Permit Number: 2007 010 130 **Category Code 940**
Application Number: 07AA-10130, Amndt Site Development Plan - Bld Prmt
Address:
Location Description: COMMERCE DR NE BETWEEN RENAISSANCE BLVD NE AND MERCANTILE AVE
NE
Project Number: 1003145

APPLICATION NO. 07AA-10130	PROJECT NO. 1003145
PROJECT NAME Renaissance Center	
EPC APPLICATION NO.	Ron Bohannan
APPLICANT / AGENT Tierra West LLC	PHONE NO. 858-3100
ZONE ATLAS PAGE F-16	
(SDP for SUB), (SDP for BP), (FINAL PLATS), (MASTER DEV PLAN), (IR), (AA)	
ONE STOP COMMENT FORM LOG

**RE: ADMINISTRATIVE AMENDMENT (AA)
TRACT 7A RENAISSANCE CENTER
ZONE ATLAS PAGE F-16**

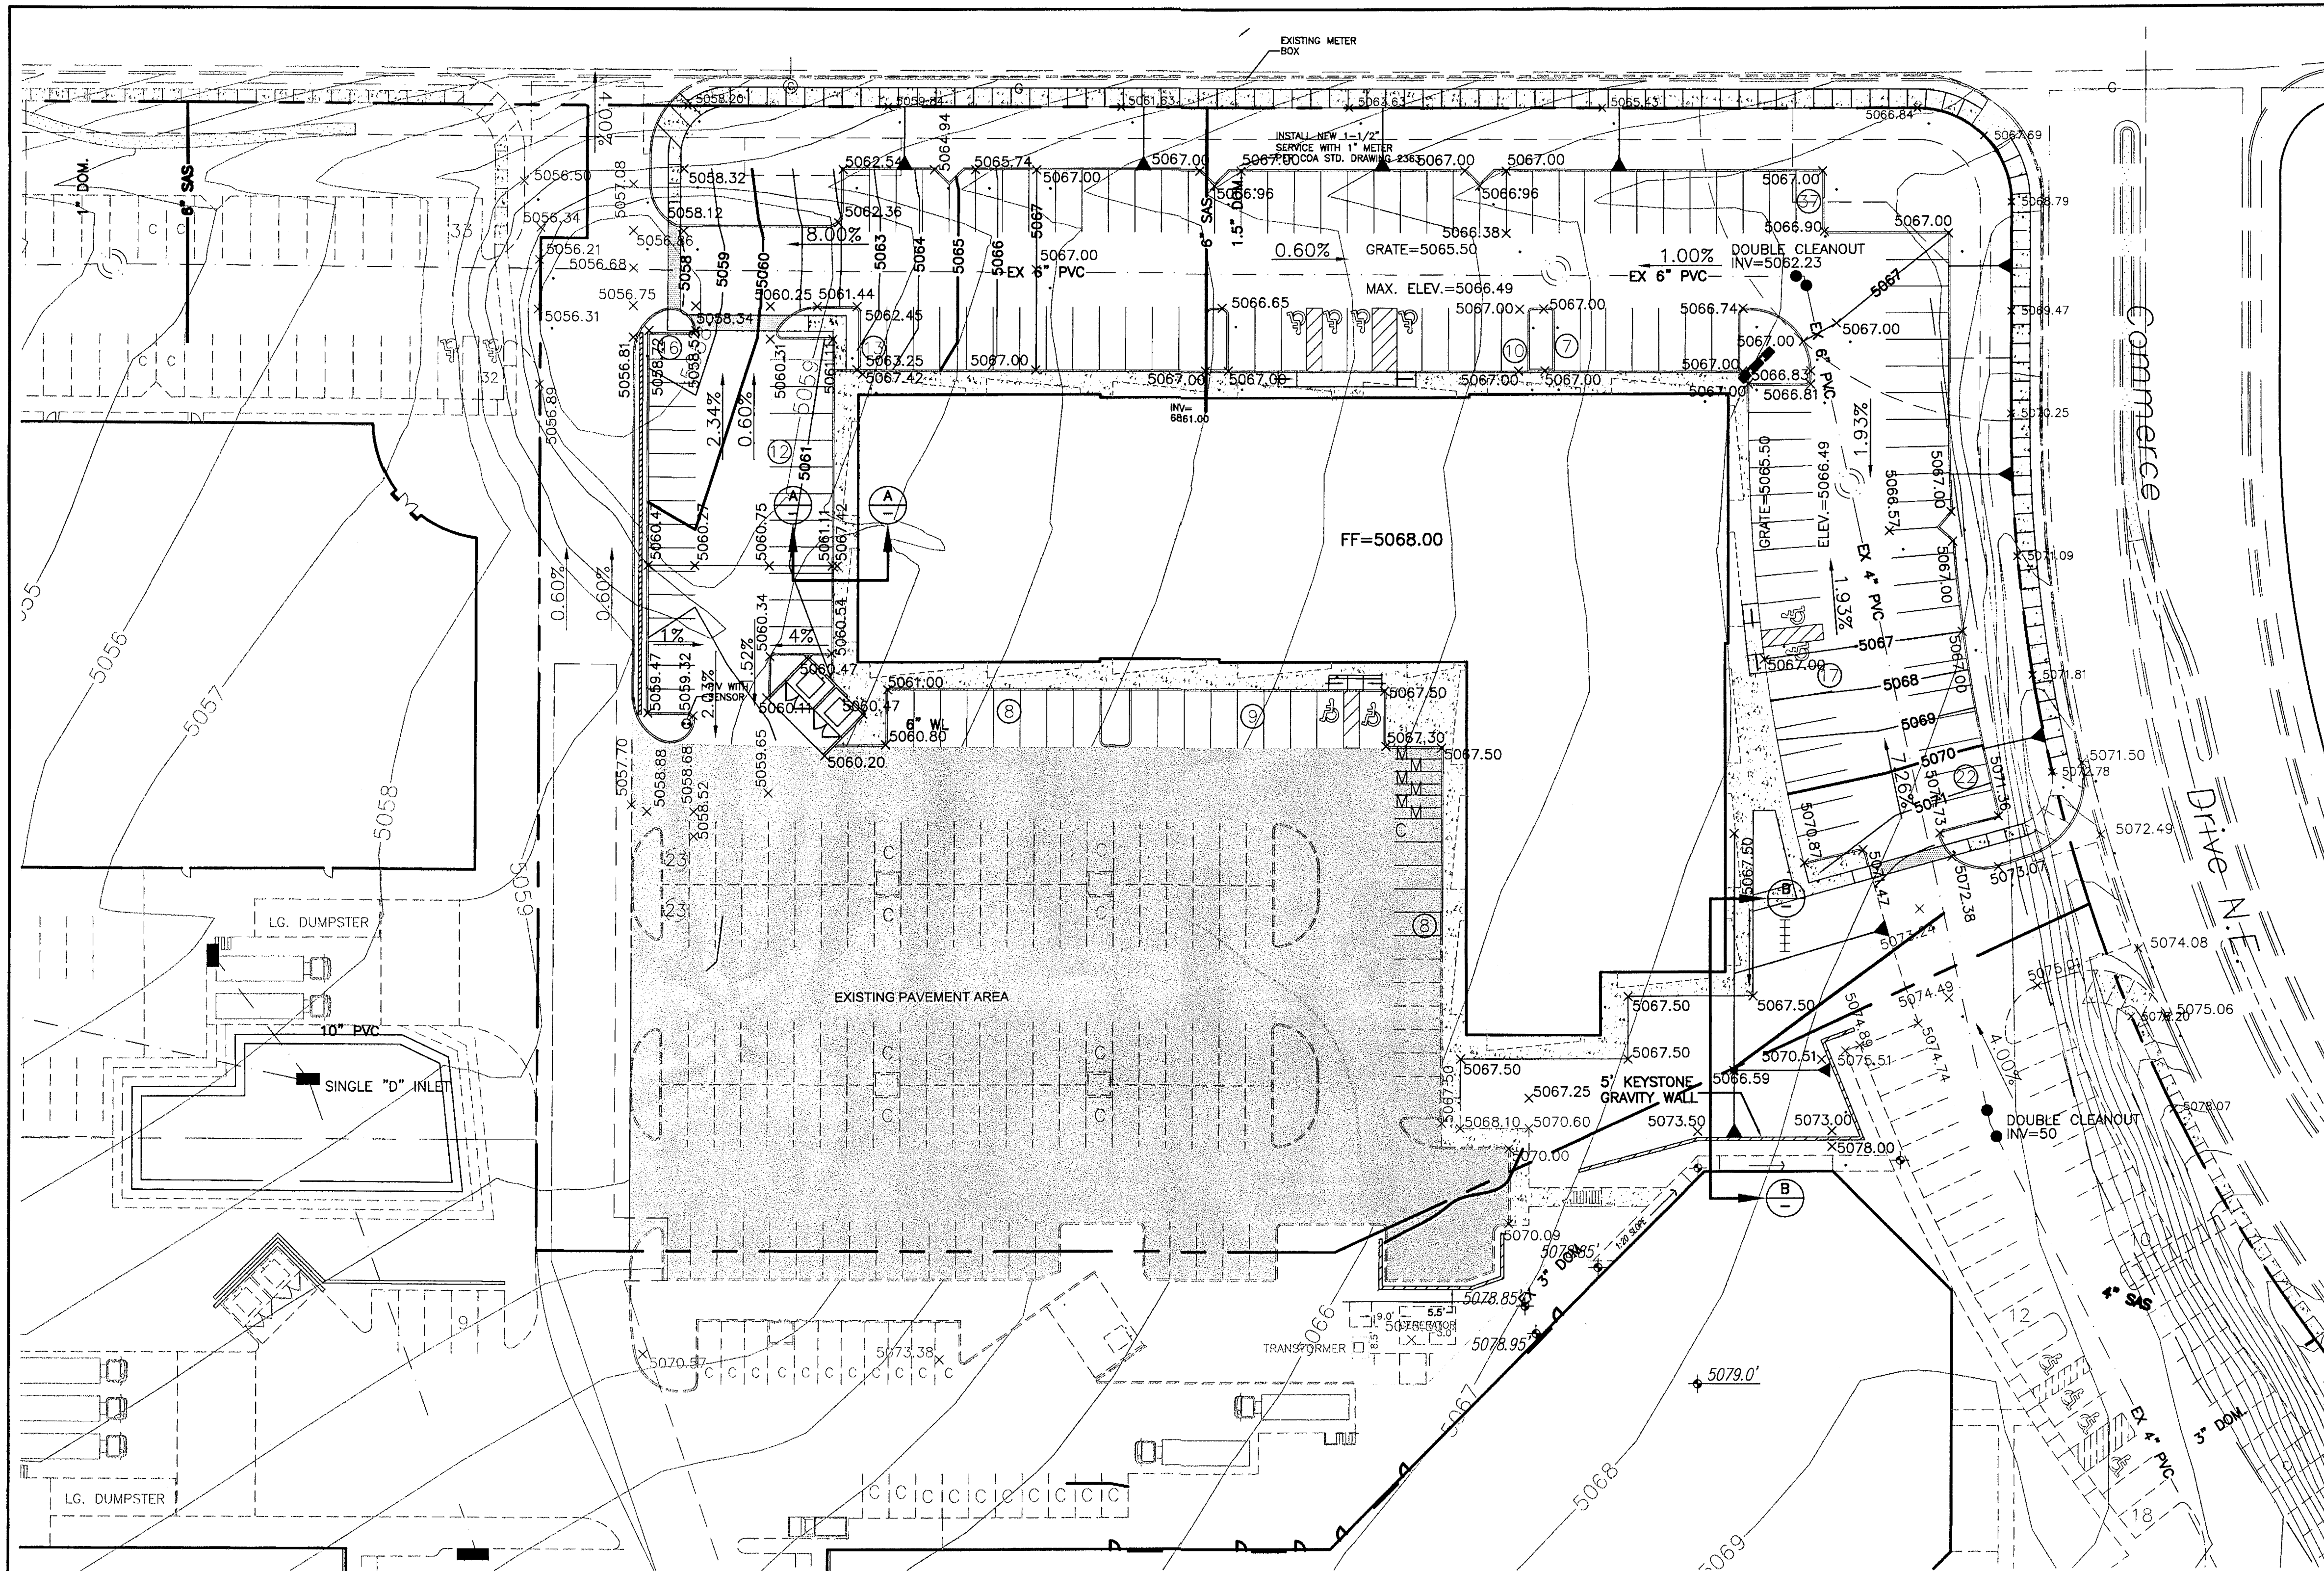
TRANSPORTATION DEV (505) 924-3990		
PLANS DISAPPROVED <i>NSF</i>	DATE 12/11/07	DATE <i>NSF</i> 01/09/08
PLANS APPROVED <i>NSF</i>	DATE 01/09/08	DATE
COMMENTS:		
<i>See Site Plan marked - Transp' 12/11/07 (addressed)</i>		
<i>- Status for cross access easement for shared entrances off Renaissance and Commerce</i>
